**Consultation Response from KC,  
Highways Development Management**

**2025/90708 Land at, Merchant Fields Farm, off Hunsworth Lane, Cleckheaton**

**Recommendation – Further Information Required**

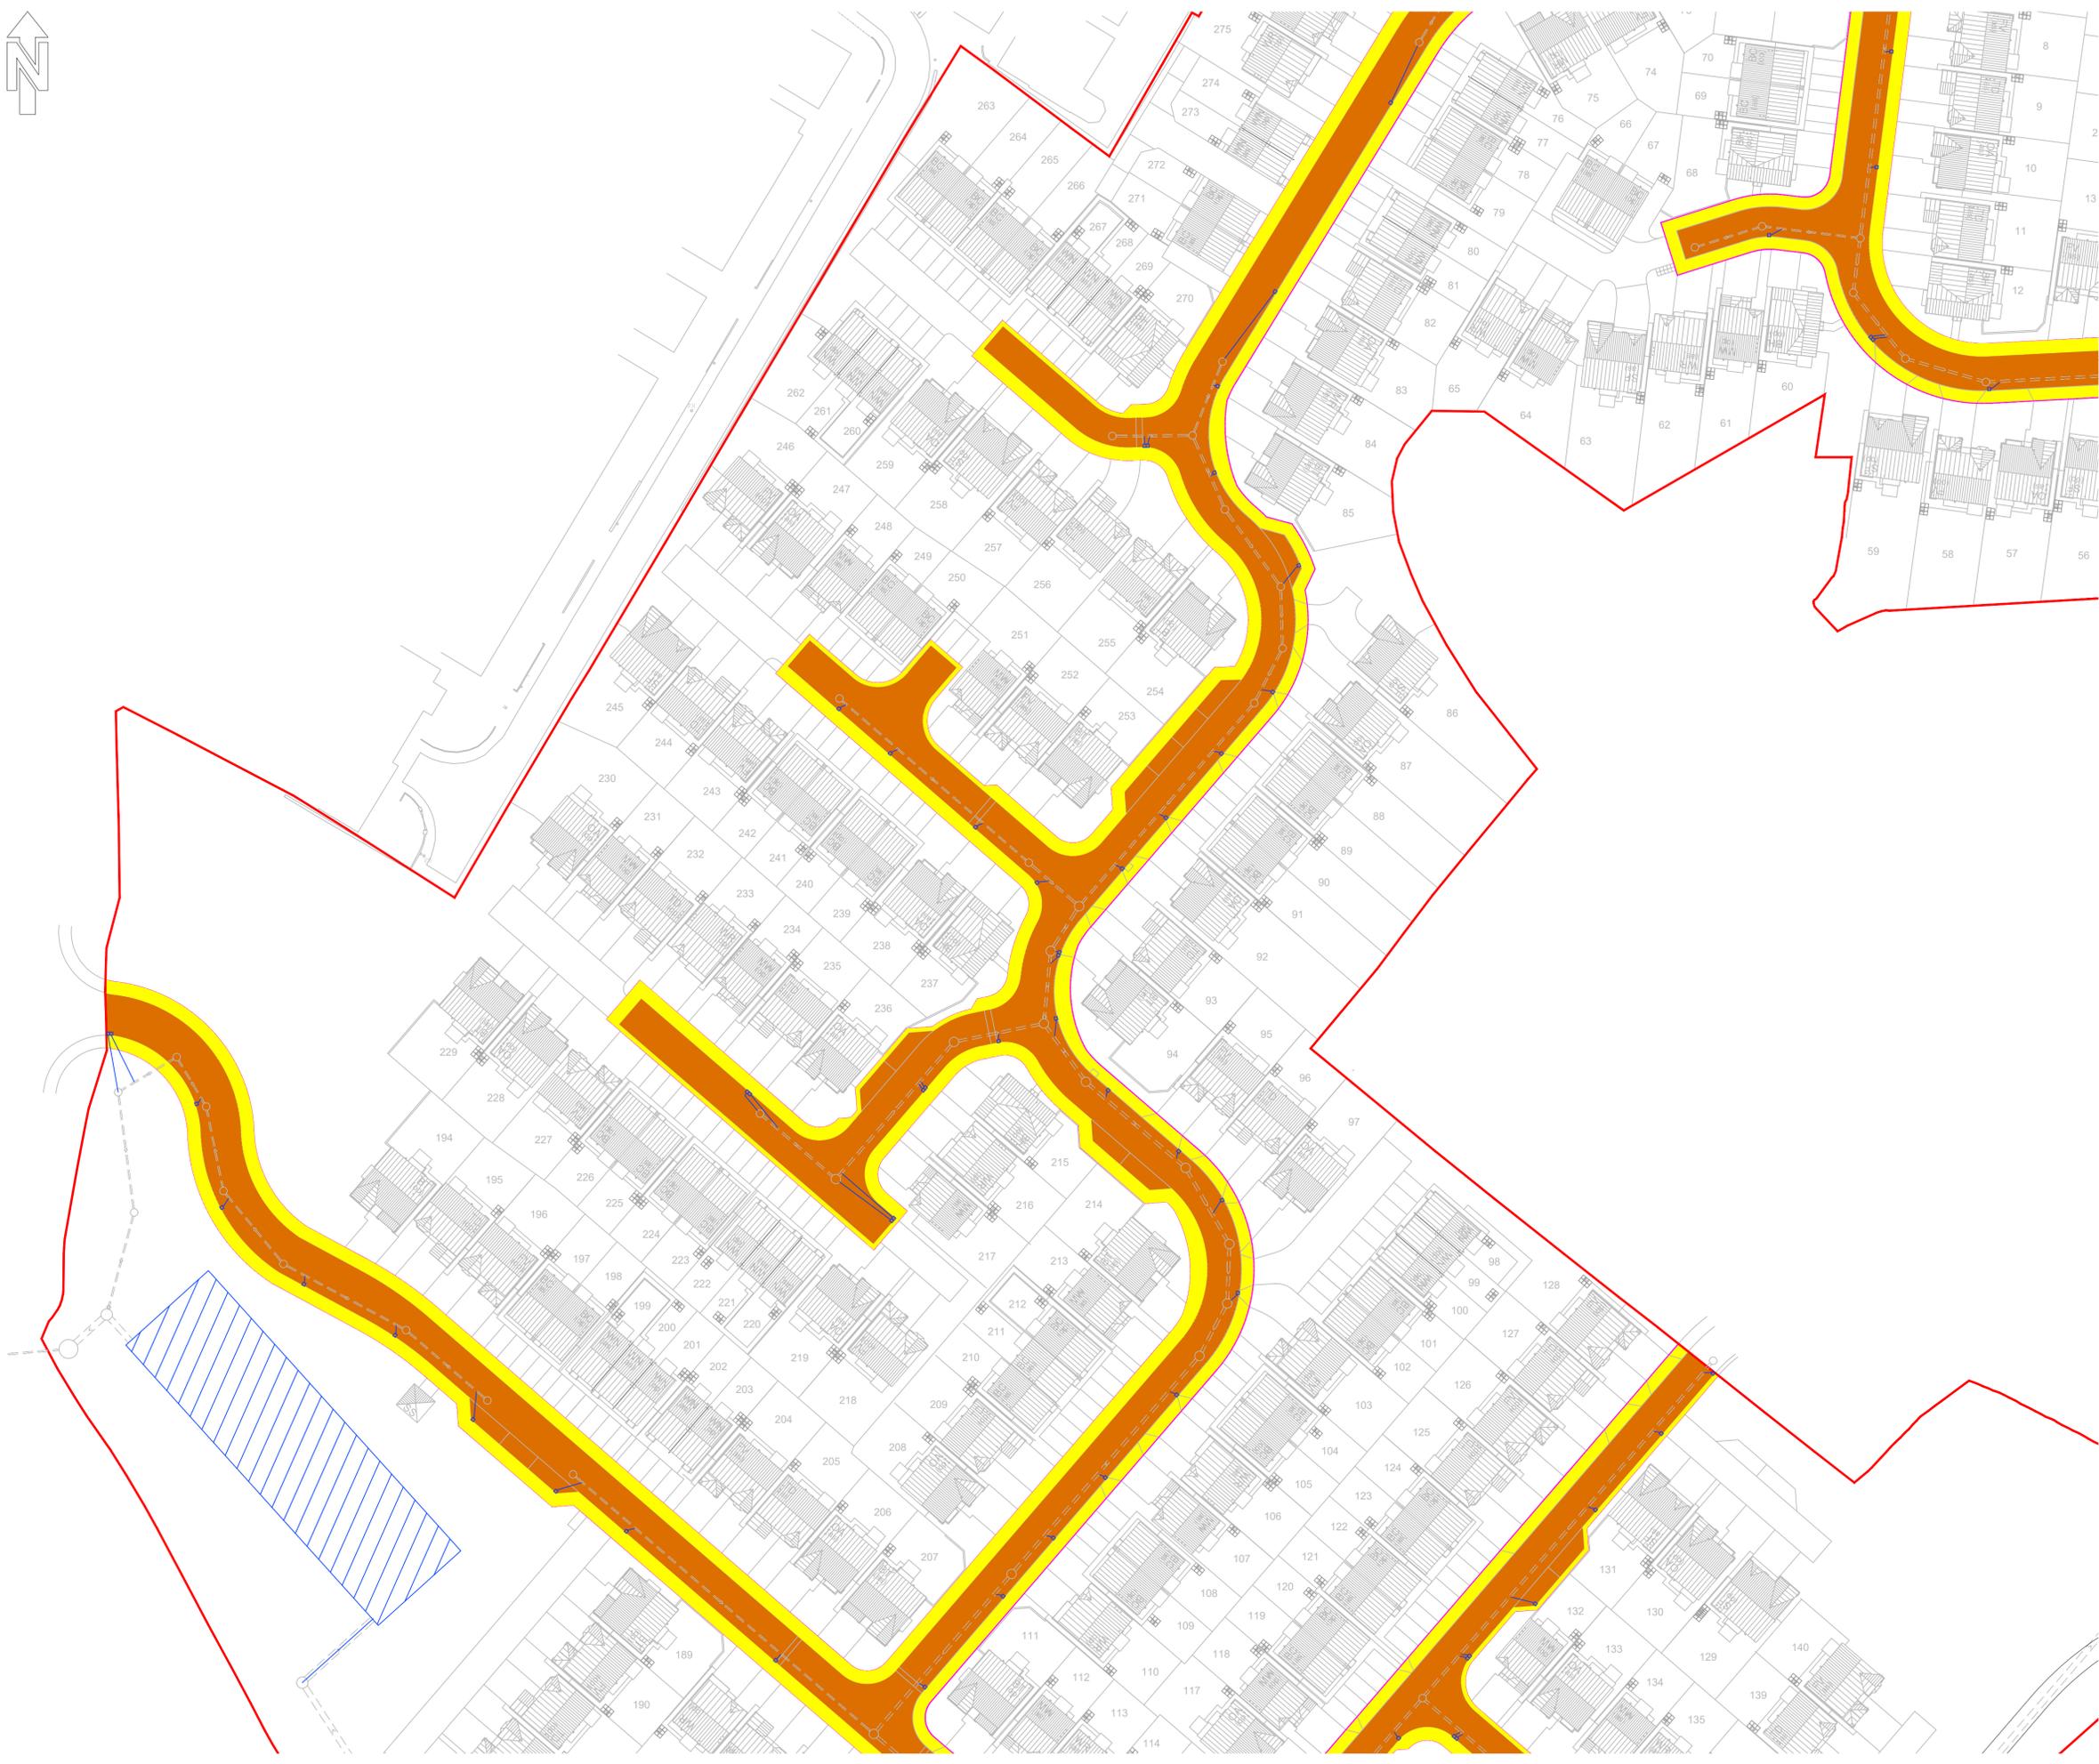
To ensure the internal road layout is suitable for adoption the Applicant will need to gain technical approval from the Highway Authority's Highway Adoptions Team. The Highway Adoptions Team has reviewed the information submitted and advised the Applicant that further information is required. Until the issues raised have been satisfactorily addressed and it has been confirmed by the Highway

Adoptions Team that the roads are of a design and specification suitable for adoption the condition should not be discharged.
